Tween Bridge Solar Farm

9.13 Statement of Common Ground with South Yorkshire Fire & Rescue Service

Deadline 1 May 2026

Document Reference: 9.13

### Figure 2.2b: Indicative Operational Layout Plan (Fixed and Tracker Solar Panel)

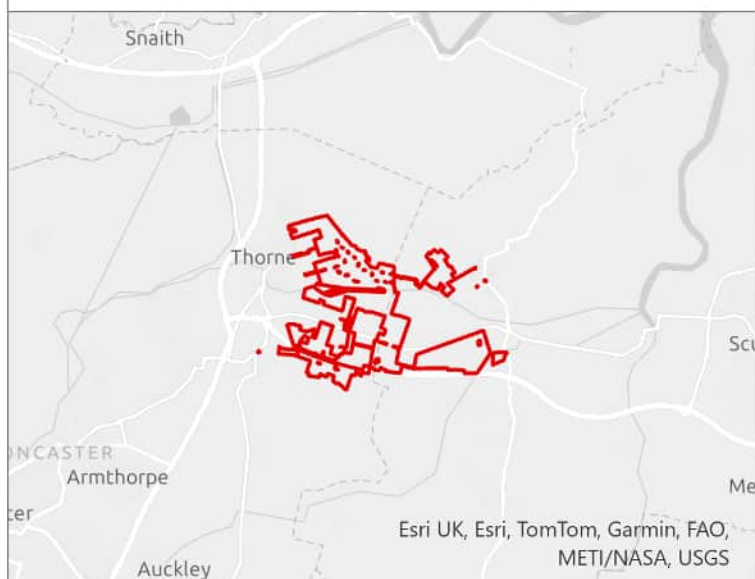
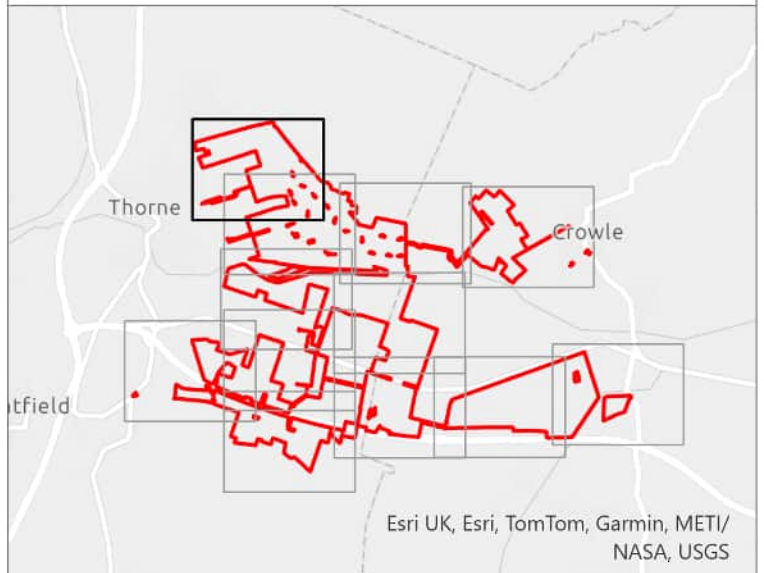
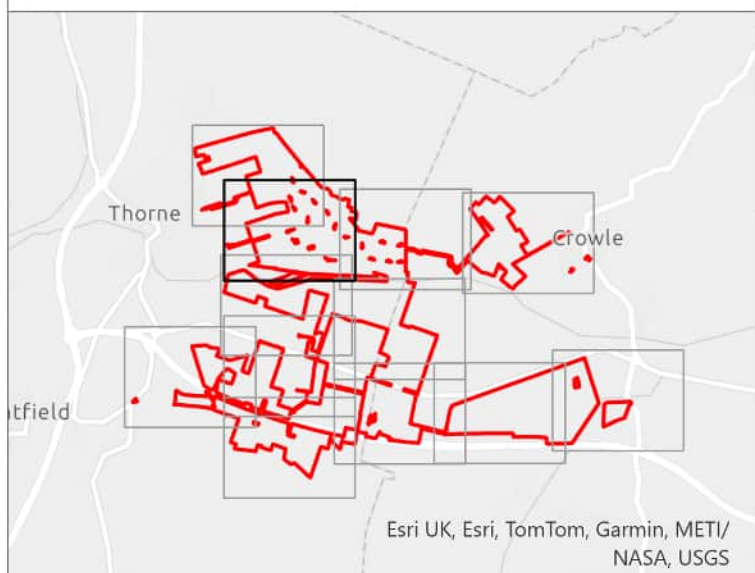
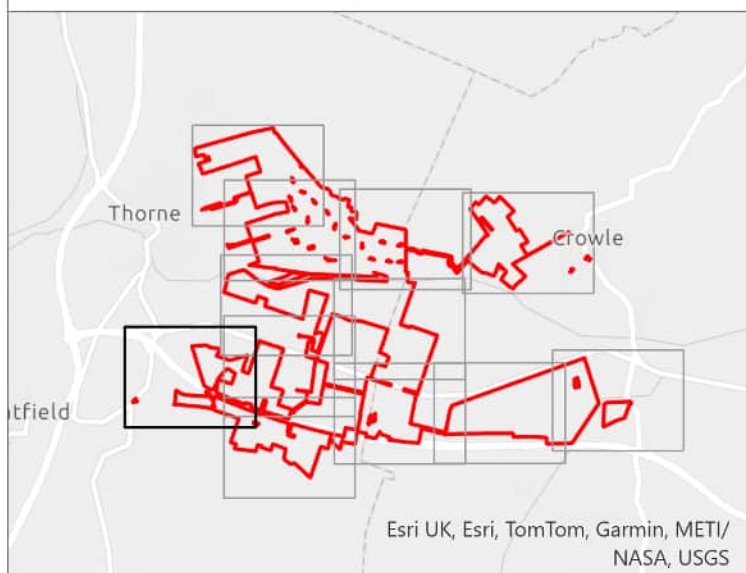
beyond site perimeter	However, an initial minimum distance of 30m is proposed prior to any mitigation such as blast walls. This distance is based upon the 100ft distance cited in NFPA 855 for remote installations.		
SYFR 12	Environmental Impact	<p>A well-developed fire involving BESS may have a large negative impact on the local environment. The Environment Agency should be involved at an early stage to discuss ways in which the environmental impact of this can be mitigated.</p> <p>A plan should be prepared to assist in discussions with developers and planners regarding the suitability of a site location highlighting all sensitive receptors within a 1km radius of the site to allow for appropriate emergency planning.</p> <p>Examples of sensitive receptors may include:</p> <ul style="list-style-type: none"> 3.1.6. Schools, hospitals, nursing and care homes, residential areas, workplaces. 3.1.7. Protected habitats, watercourses, groundwater, boreholes, wells and springs supplying water for human consumption. Further habitat information can be found 	<p>The Applicant agrees environmental context is important when locating BESS. Specific plans for sensitive receptors for the BESS have not been prepared. However, the receptors have been identified in the baseline assessments supporting the Environmental Statement which have informed the location of the BESS within the scheme. The locations of the BESS are illustrated in Environmental Statement Figure 2.2a: Indicative Operational Layout Plan (Fixed Solar Panels) [APP-134] and Environmental Statement Figure 2.2b: Indicative Operational Layout Plan (Fixed and Tracker Solar Panels) [APP-134].</p>	Under discussion
